# **LOCAL IMPACT REPORT**

## **BROADLAND DISTRICT COUNCIL**

**APPLICATION BY: Norfolk Boreas Limited for an Order Granting  
Development Consent for the Norfolk Boreas Project.**

**PLANNING INSPECTORATE REF: EN010087**

CAWSTON HIGH STREET - INTERVENTION SCHEME  
Scale 1:500

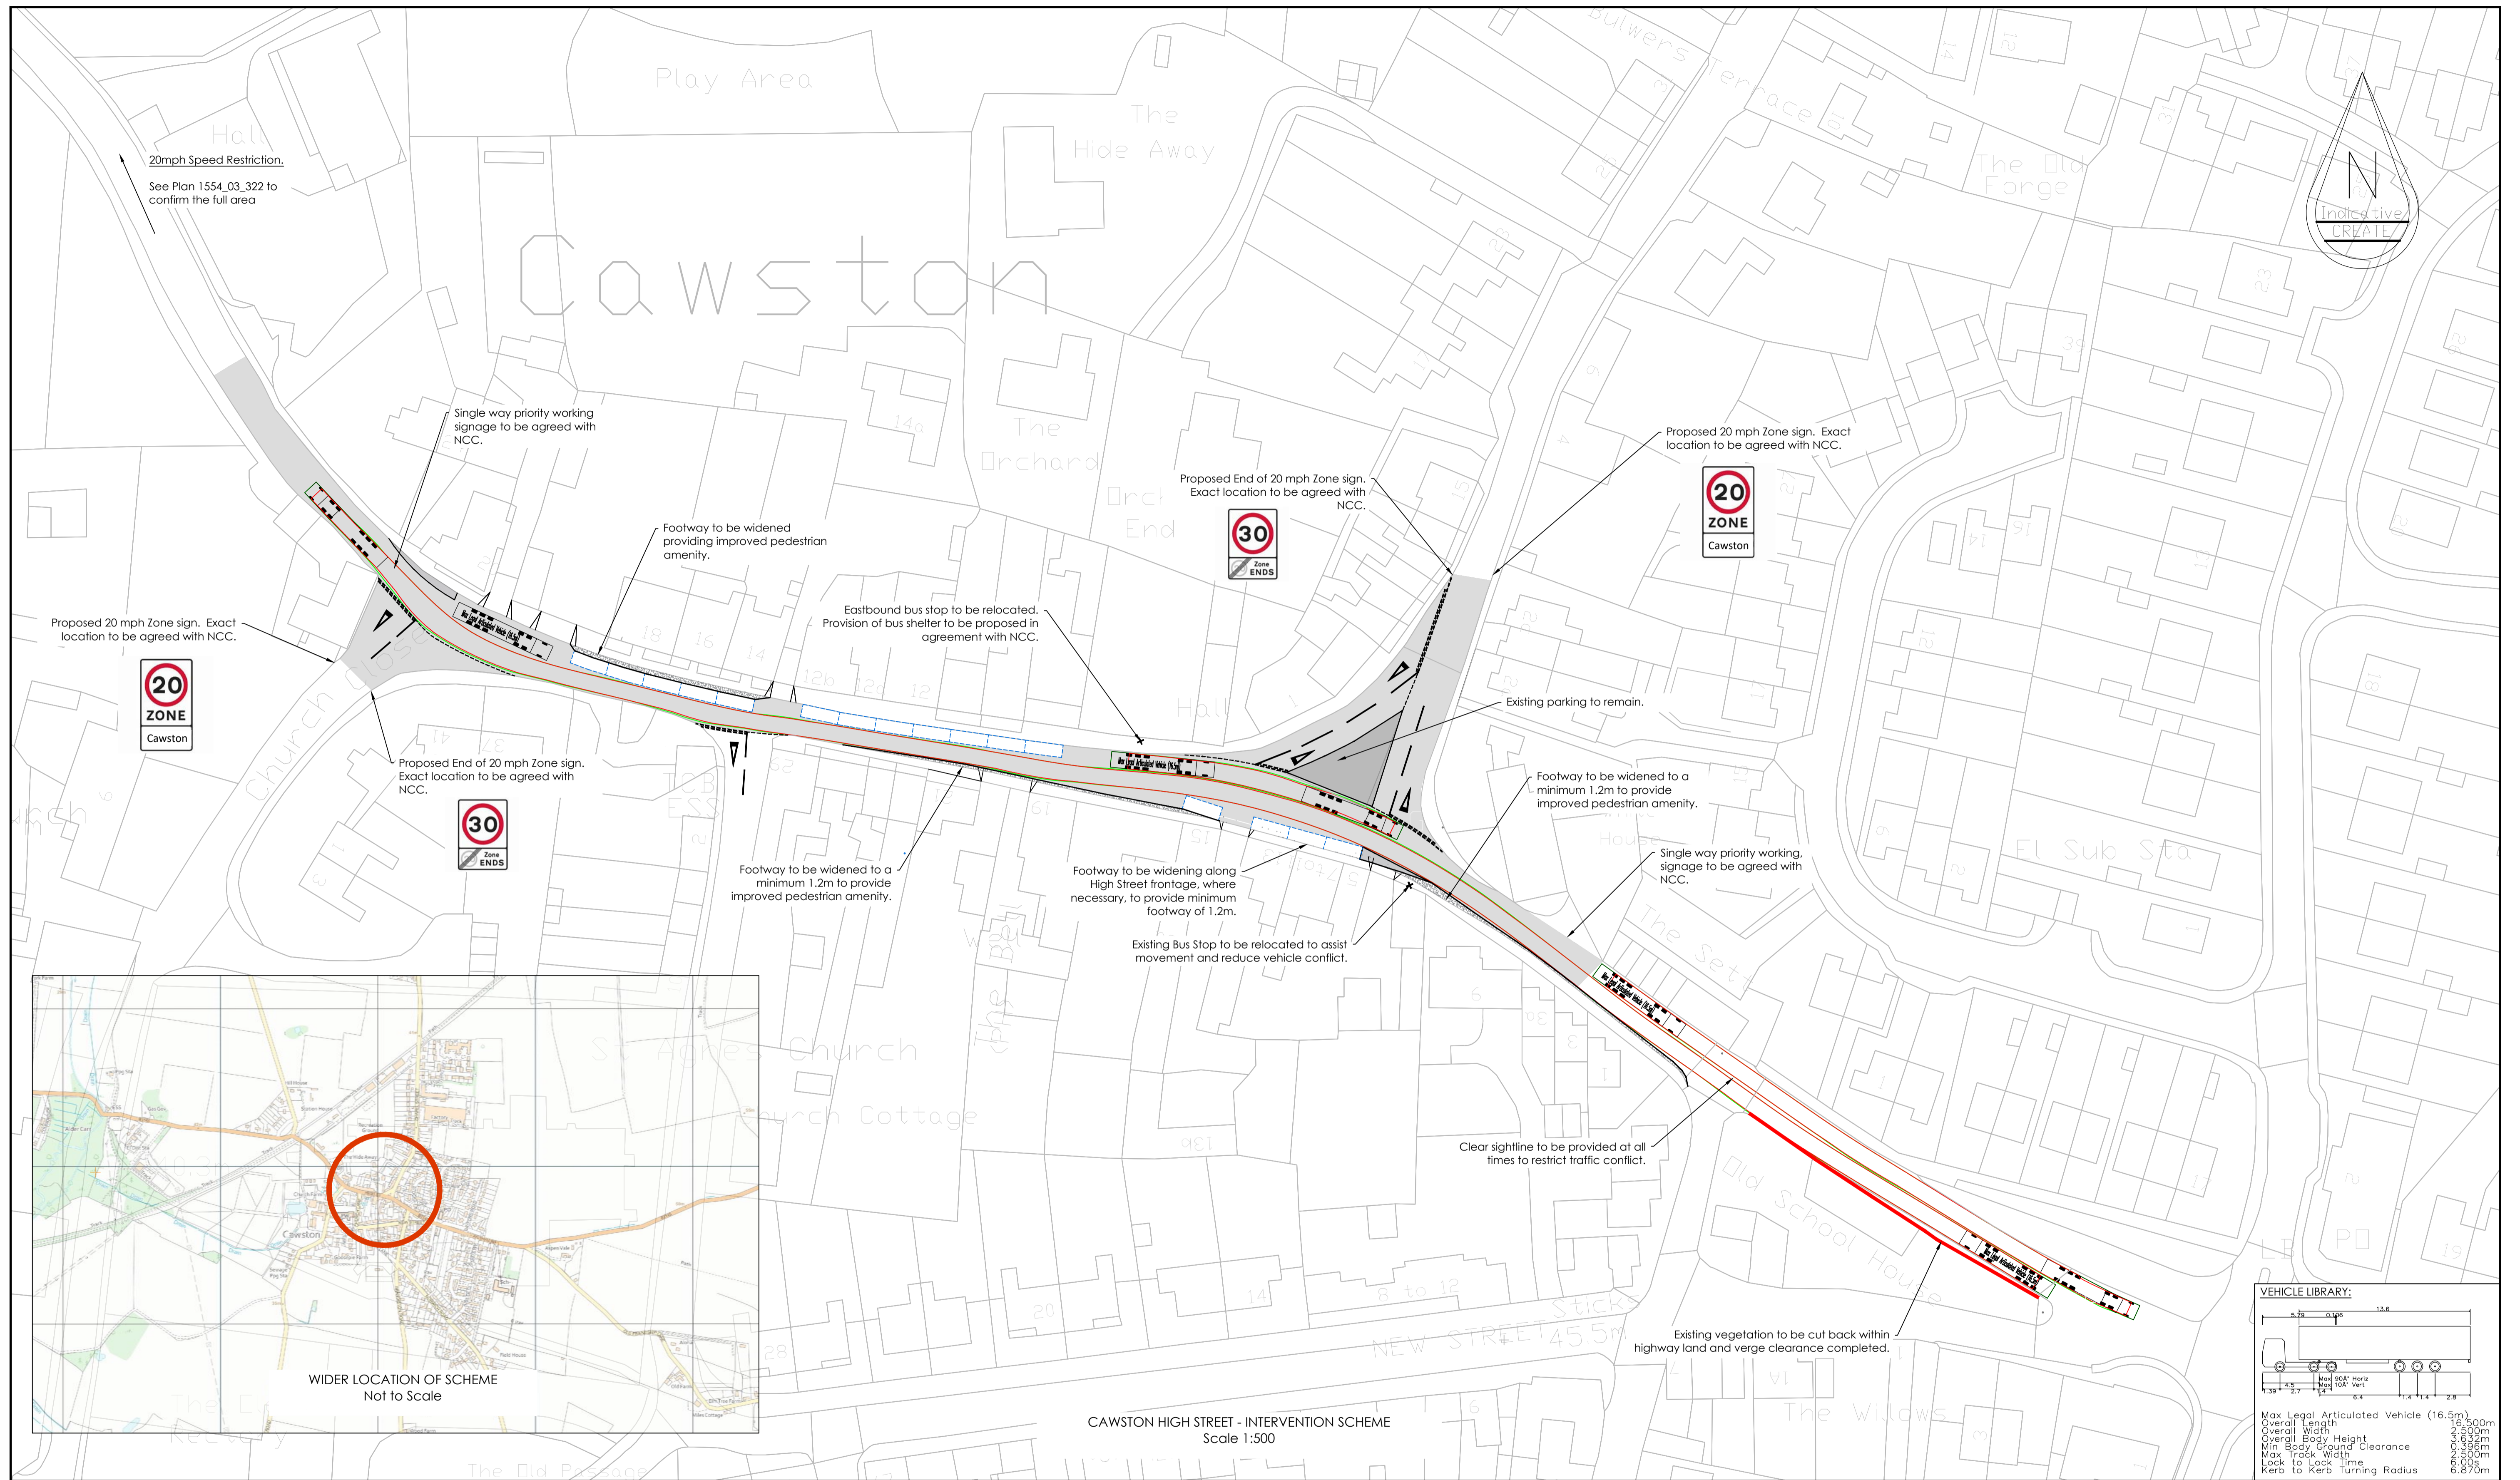
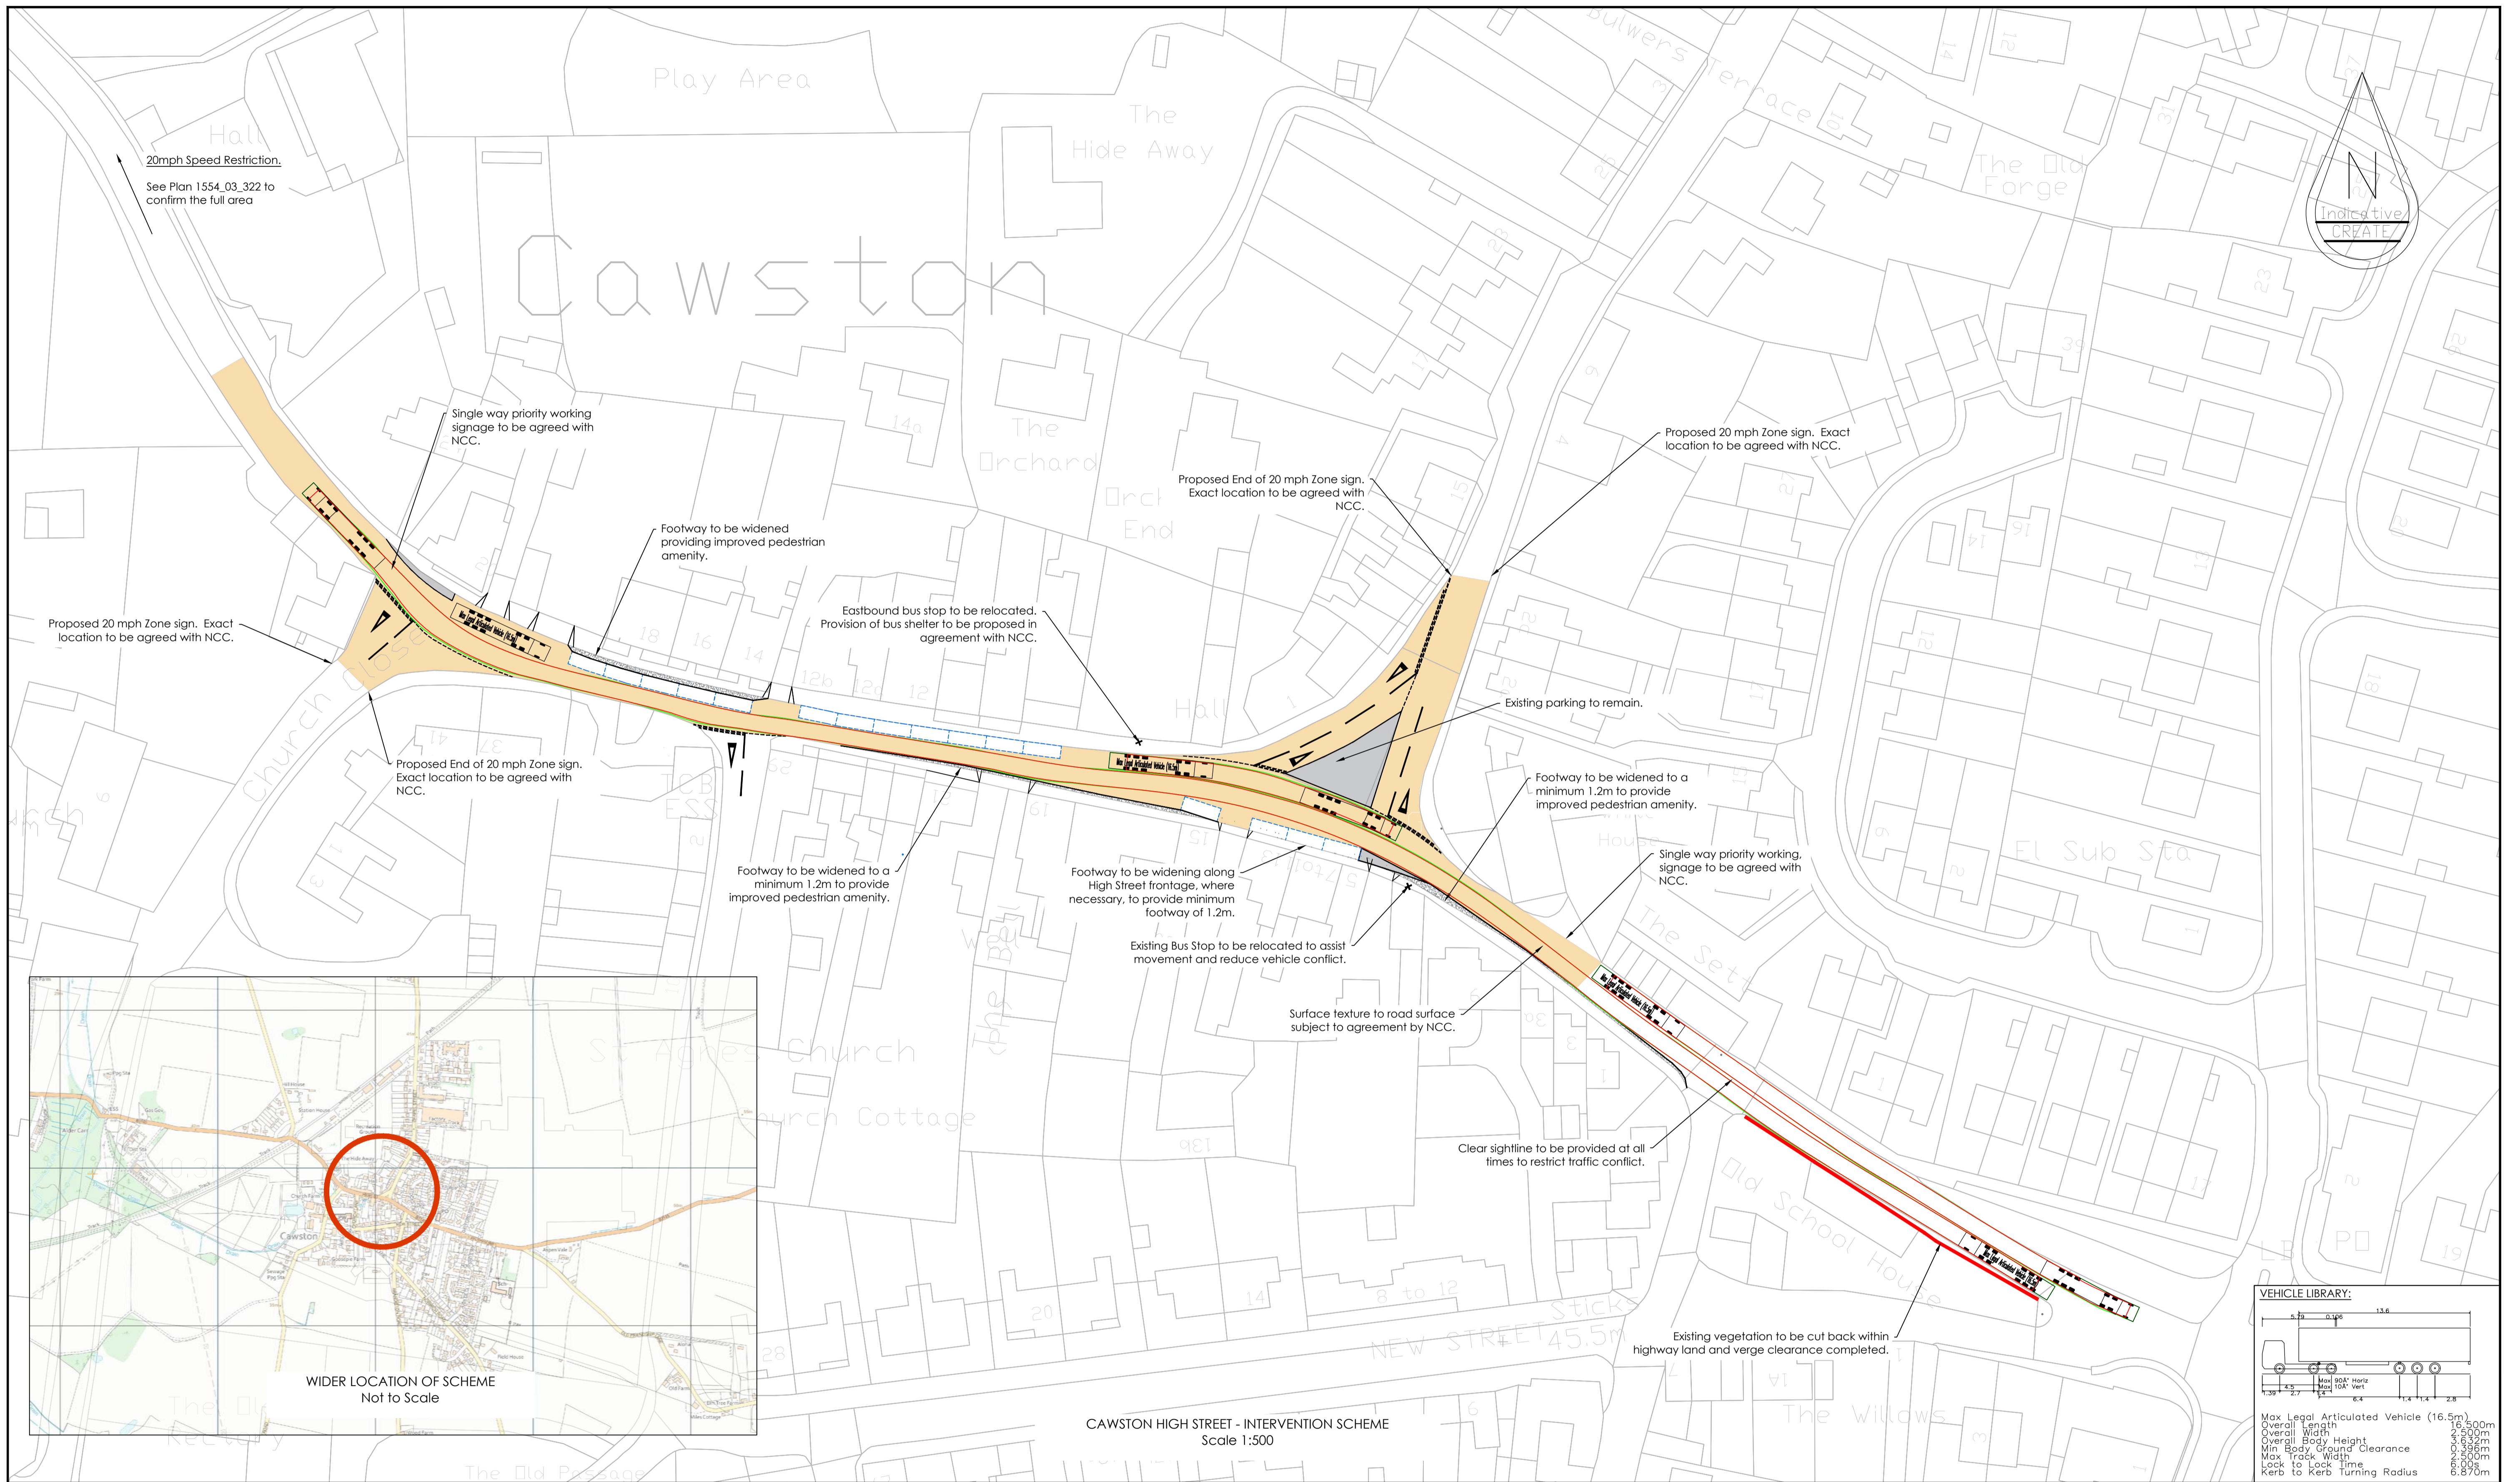
5.9 Both the Hornsea Three and Norfolk Vanguard projects propose a traffic mitigation scheme within the village centre of Cawston along the High Street to include dedicated on-street parking areas, footway widening/carrageway narrowing with the formation of waiting areas either side of the centre so that only single way HGV's can manoeuvre through a section of the village centre at a time with a reduced speed limit and the carrageway re-surfaced. The mitigation scheme is still to be finalised in the respective Construction Traffic Management Plans, should approval for each project be forthcoming. As a result of the Norfolk Vanguard proposals the total number of HGV's passing
